DECISION DELEGATED TO HEAD OF PLANNING

Application No: H23-0527-24 **Applicant:** Mr & Mrs Fitzgibbon
Proposal: Proposed pre-fabricated concrete garage
Location: New Saracens Head Washway Road Saracens Head
Terminal Date: 14th August 2024

This is an application for a Lawful Development Certificate to confirm that the proposed erection of a detached garage is lawful and does not require the submission of a planning application.

Project: Proposed erection of a Garage

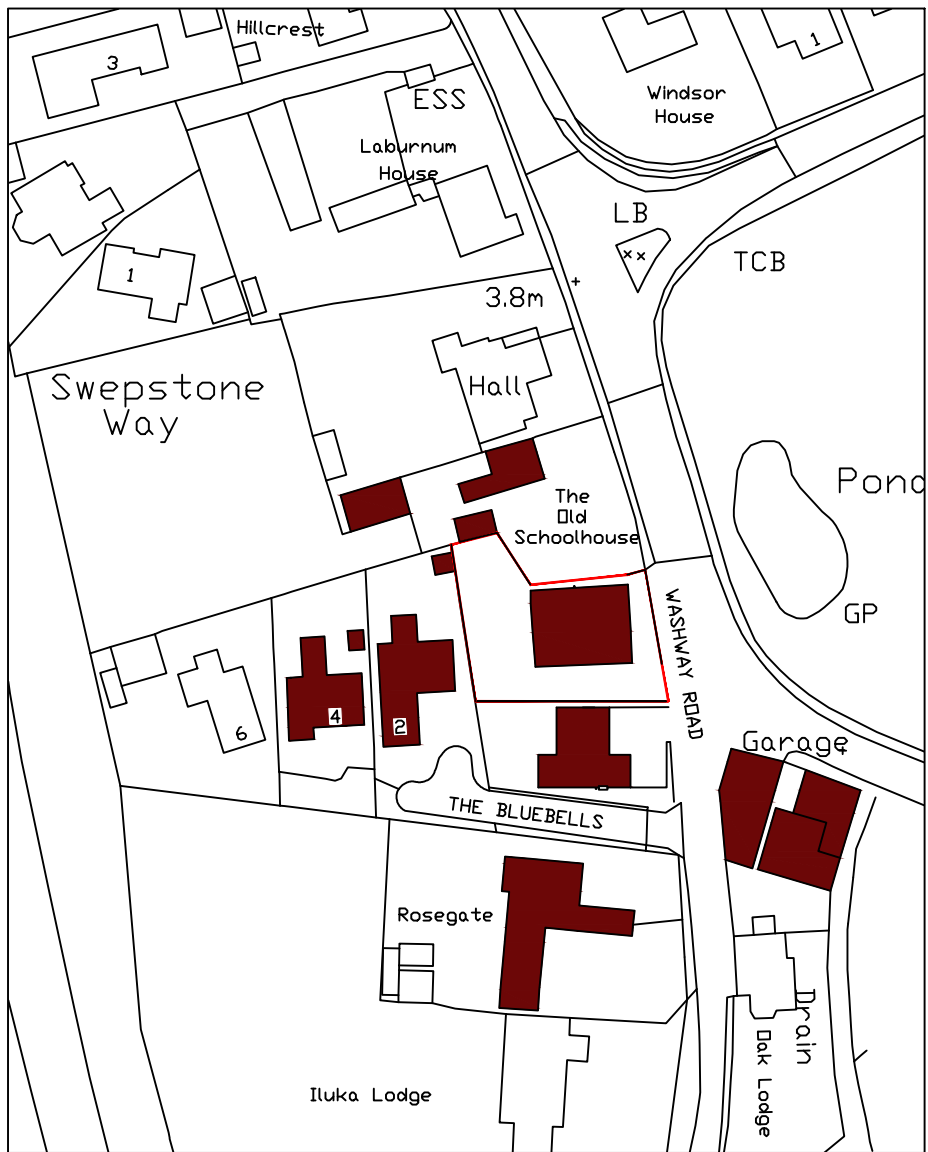
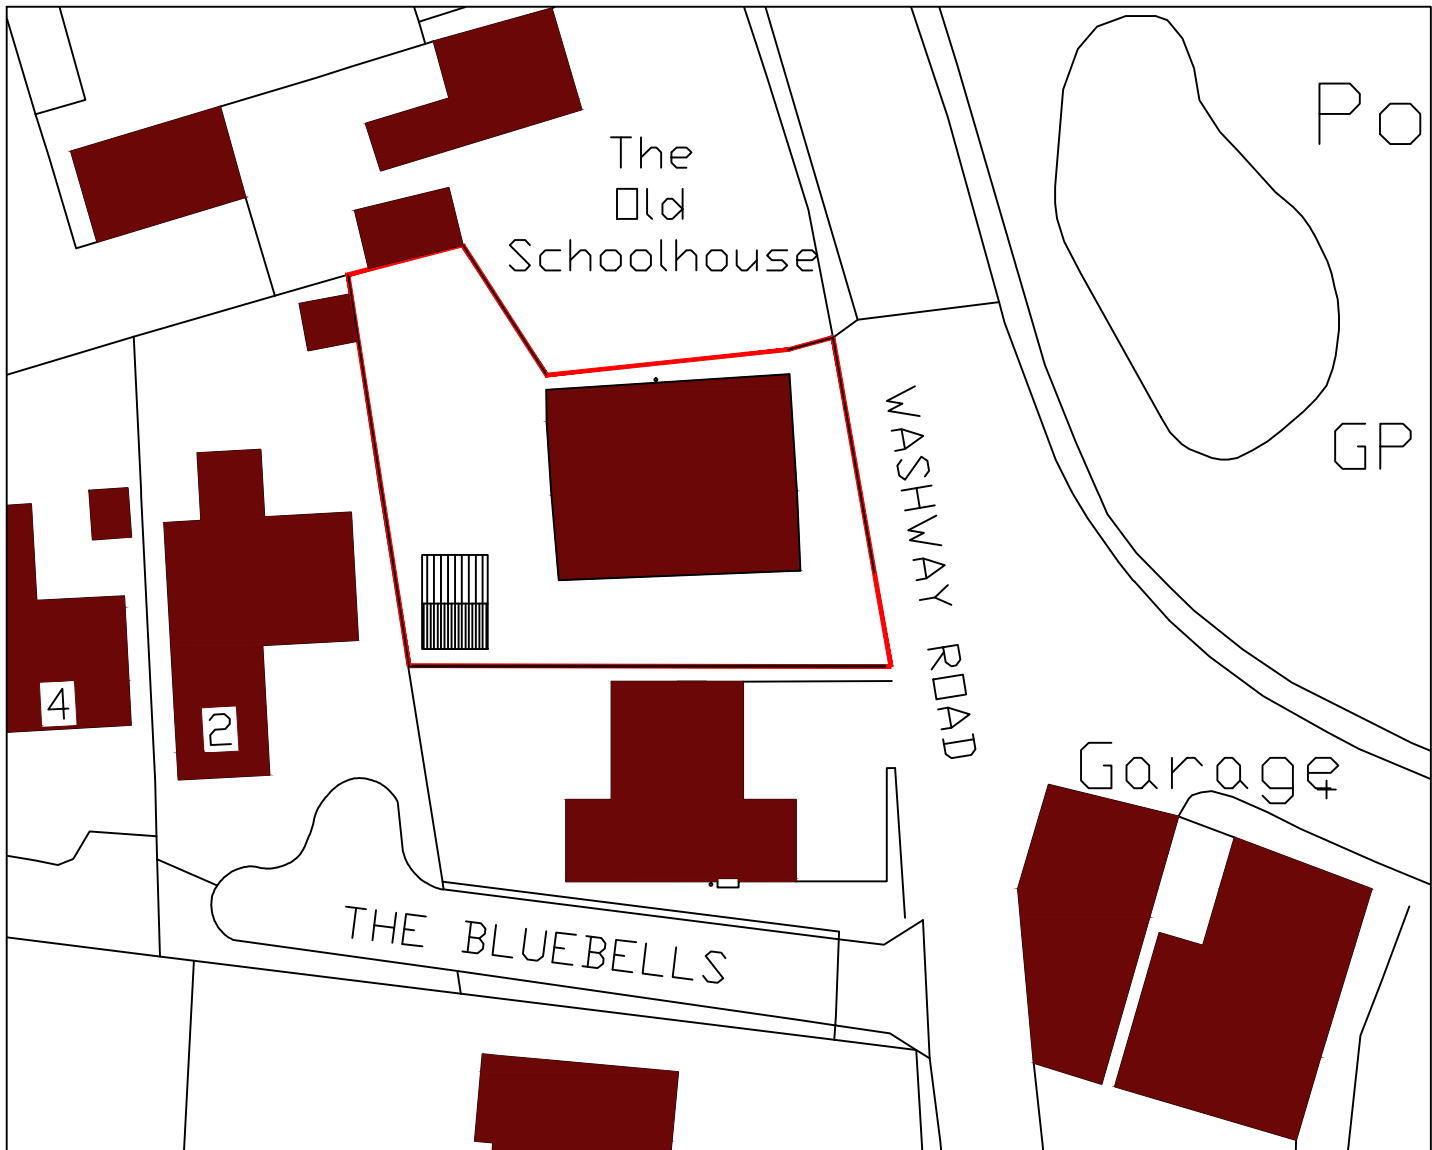
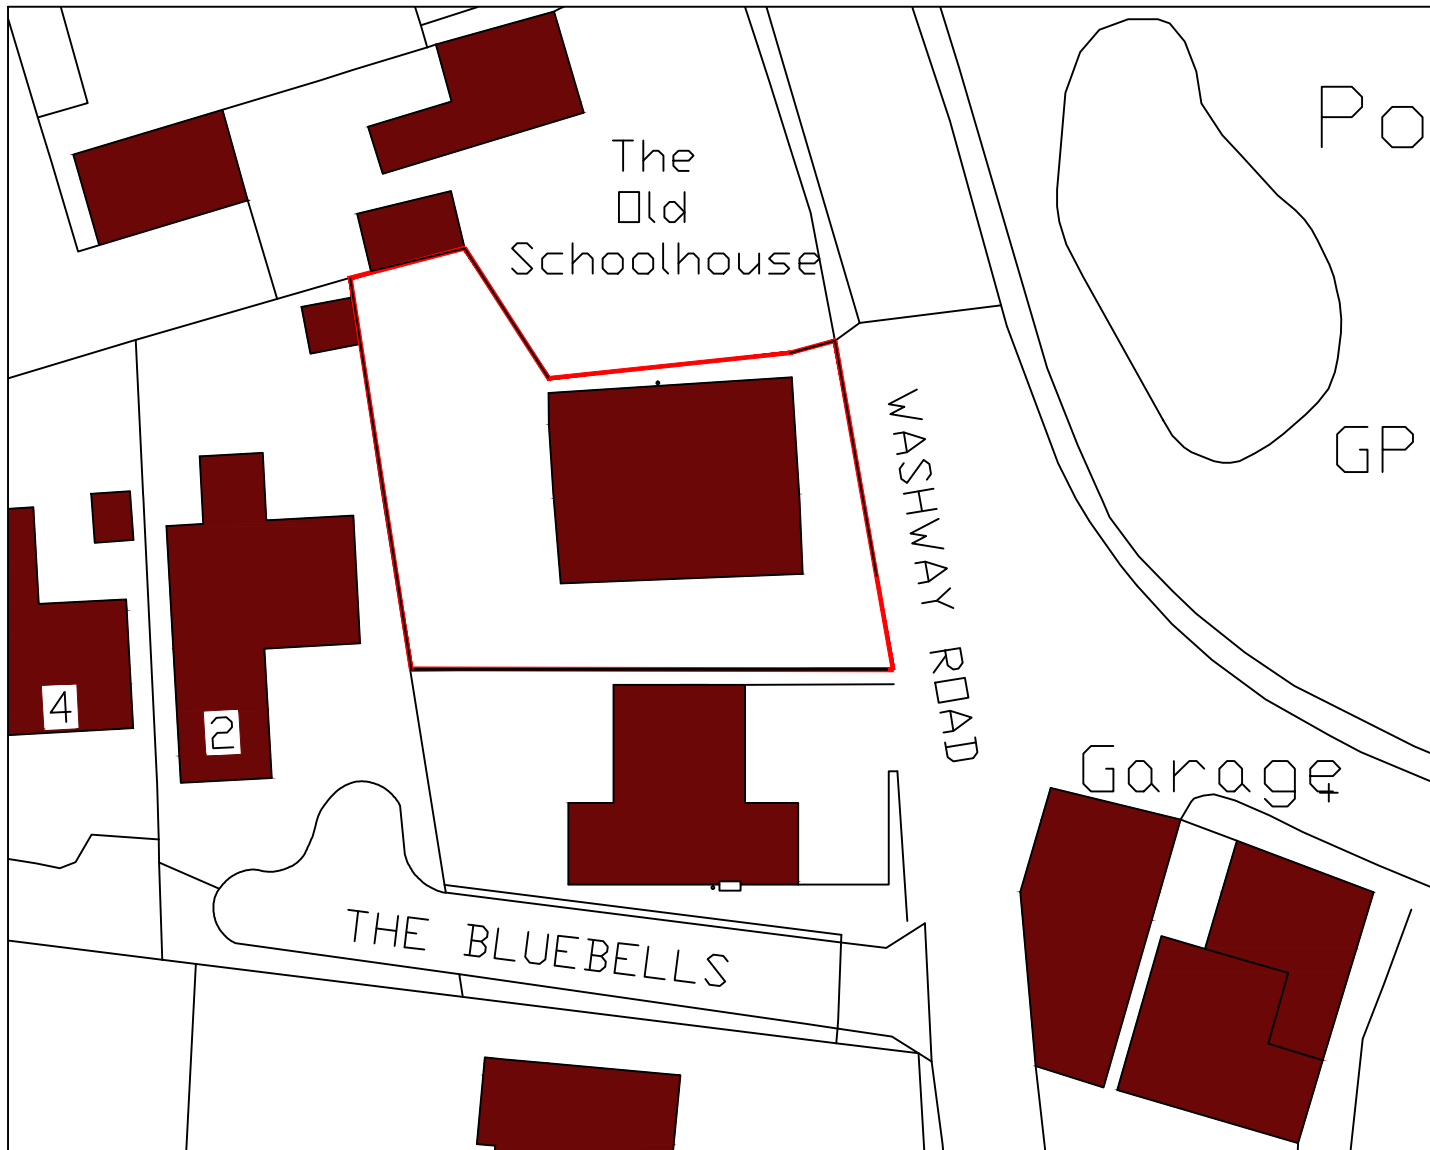
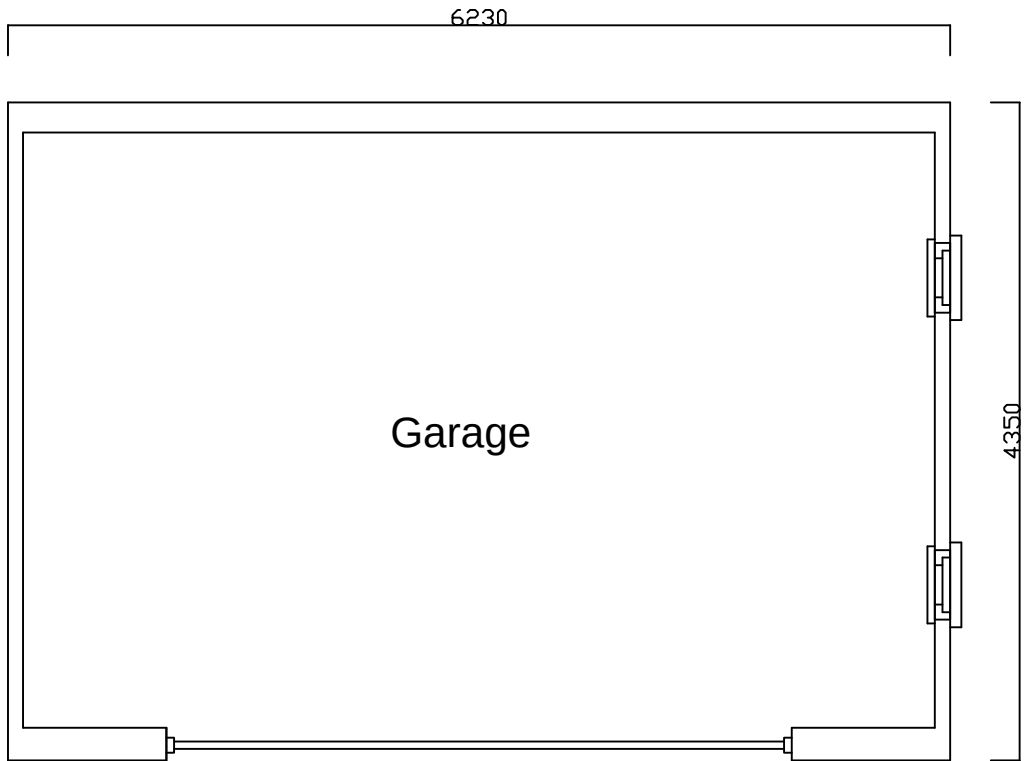
The building is located within 2m of the boundary, however, the maximum height of the building would be 2.48m with an eaves height of 2.010m and therefore complies with (e).

The eaves height of the proposed building would be a maximum of 2.010m and therefore, complies with (f).
